Re: Town and Country Planning Act 1990 (as amended)
Land to the North of Littlehampton, Phase 2: Non Material
Amendment (ref LU/121/17/RES)
Planning Portal Reference: PP – 0717 1740

We hereby submit a non material amendment to amend approved plans submitted with the Reserved Matters application (LU/121/17/RES). Attached to this letter are Conditions 5 and 7 of the outline consent.

We are seeking to replace the approved External Wall Finishes Plan Brick (ref 543_PL_SITE LAYOUT_107 Rev E) with a new plan (ref 543_PL_SITELAYOUT_107 Rev G) WHICH REPLACES THE Edenhall Dolomite Cream Brick with the Brickworks Langold Buff stock.

Littlehampton Phase 2
Outer Central Core

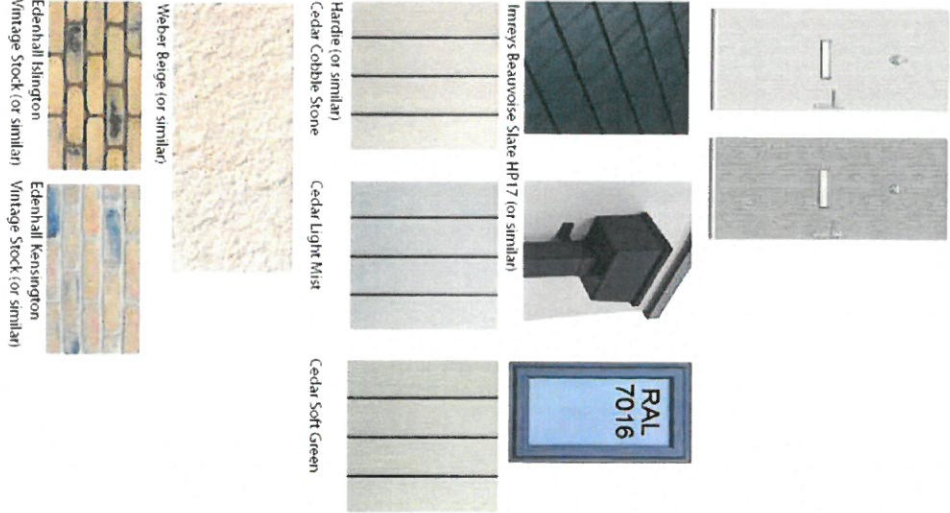
In addition, for clarity, we would like to confirm we are proposing white garage doors throughout Phase 2 and the window frame propose throughout Phase 2 will be the 7016 Anthracite. Please see updated extract from the Design and Access Statement confirming the selected window frames.
